ROAD SAFETY AUDIT FEEDBACK FORM

Scheme: Gort town Centre Public Realm Scheme

Audit Stage: 1 Date Audit Completed: 11/09/2024 Route No. Our Ref :-123316|R1

3.2.2 Pedestrian Connectivity Lowry's Lane to Town Core

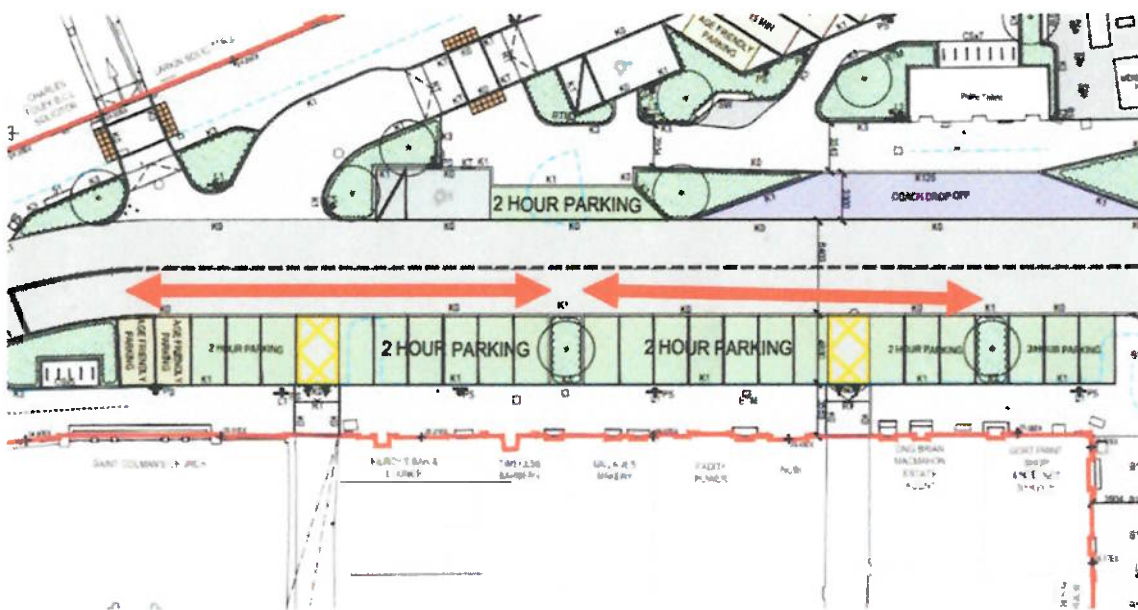
3.2.1	No	No	This is a town centre location and a 30kph zone. There are clear visible sightlines from all directions to the mini roundabout.	
3.2.2	Yes	No	We will provide a raised crossing as a shared space to enable access to the main square and traffic calming along Market Street

3.2.4 Vehicular Footpath Crossovers

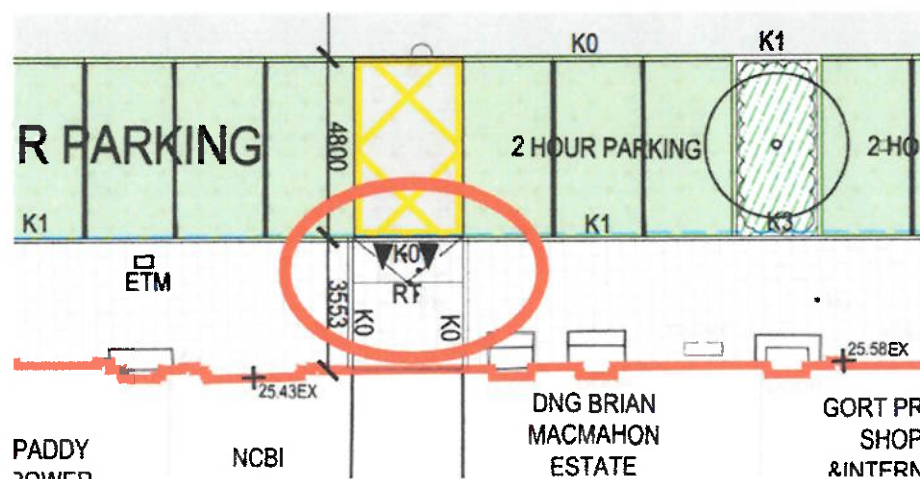
3.2.3	Yes	Yes		
3.2.4	Yes	No	This is a tried and tested detail which allows a continuous footpath level for a minimum of 2m against the building edge and then a sloped section for cars to mount. This detail ensures that there are not excessive slopes across the whole footpath and towards the channel line of the road. The paving will also be contrasting colour to demarcate this as a driveway crossover.

3.2.5 Driveway Visibility

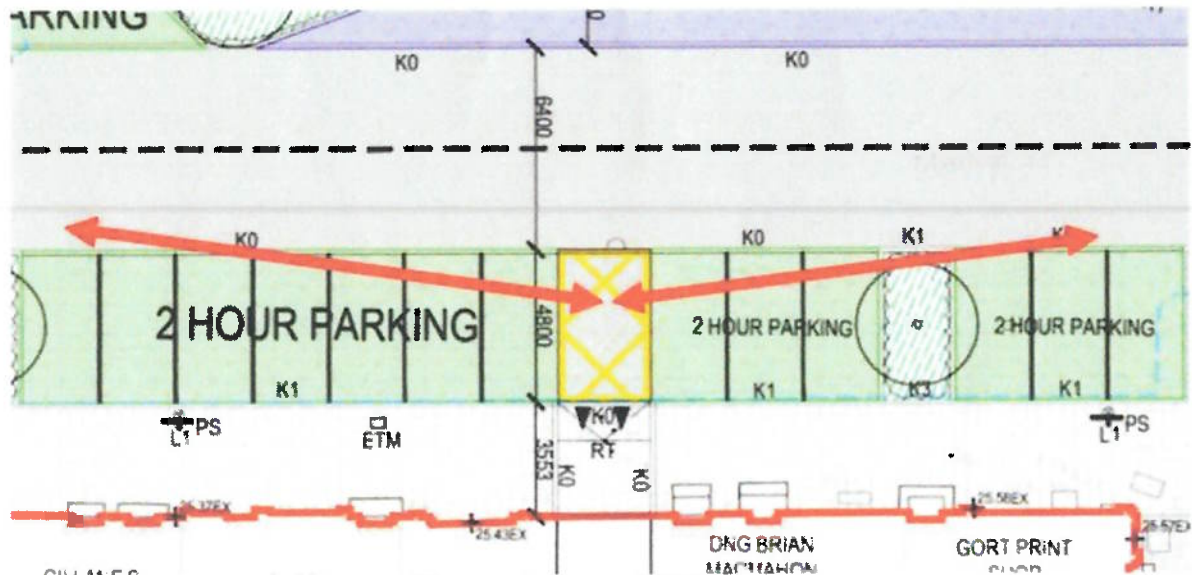
3.2.5	Yes	No	This is typical and an existing scenario within the town where there is on street parking and entrances to driveways / alleyways. Its not feasible to take out all of the parking on the streets, instead the yellow markings provide a clear space for vehicles to enter an exit. There is very low number of vehicles doing this movement.

3.2.7 Sharp Kerb Edges

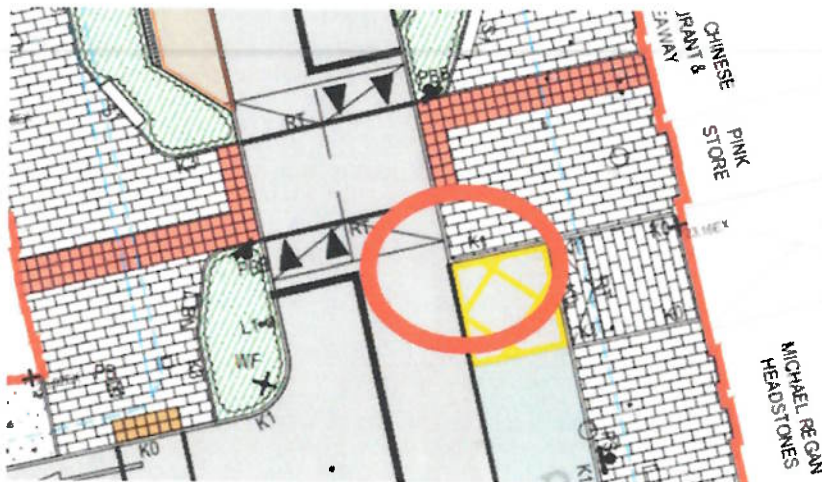
3.2.7	No	Yes	All 90 degree kerbs will be a smooth radius quadrant kerb with a bull nose top	
3.2.8	Yes	Yes

3.2.10 Coach Drop-off Bay

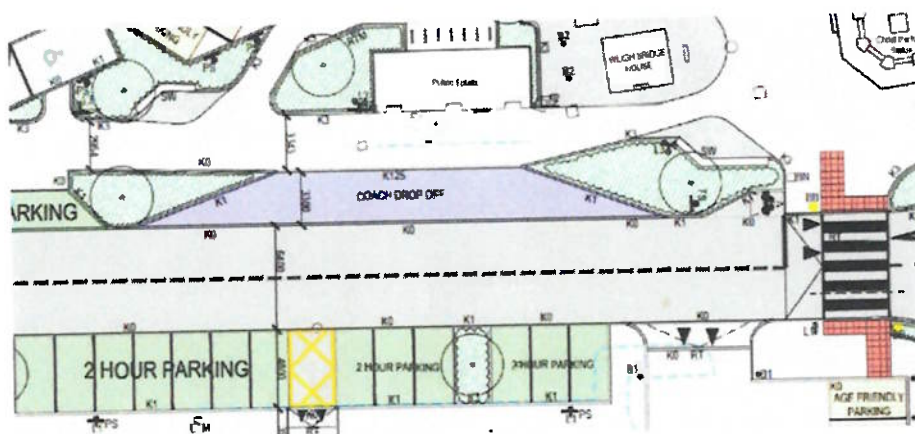
3.2.9	Yes	No	A paved margin will be provided adjacent to the kerb to assist connectivity for all vehicle passengers	
3.2.10	No	Yes	The coach will have a set route and will not turn in side streets

3.3.1 Crowe Street Car Park – Pedestrian Access

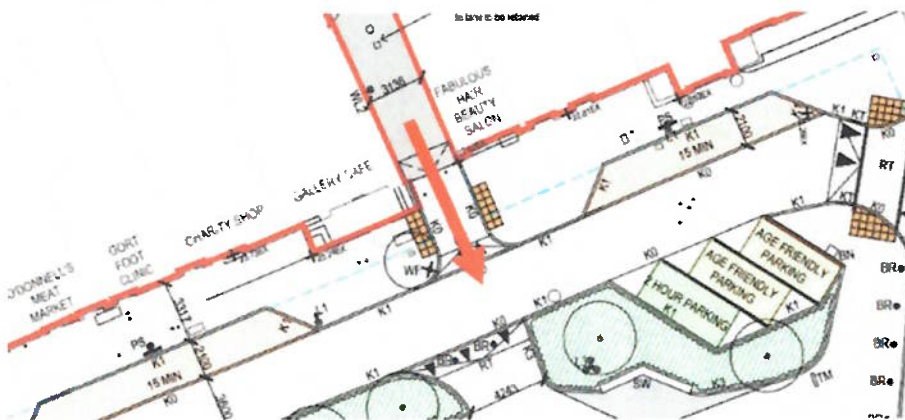
3.2.11	Yes	Yes		
3.3.1	Yes	No	Options are being considered to provide necessary vehicular access to Lowrys Lane from the new off street car park, to omit the need for vehicles to use this link
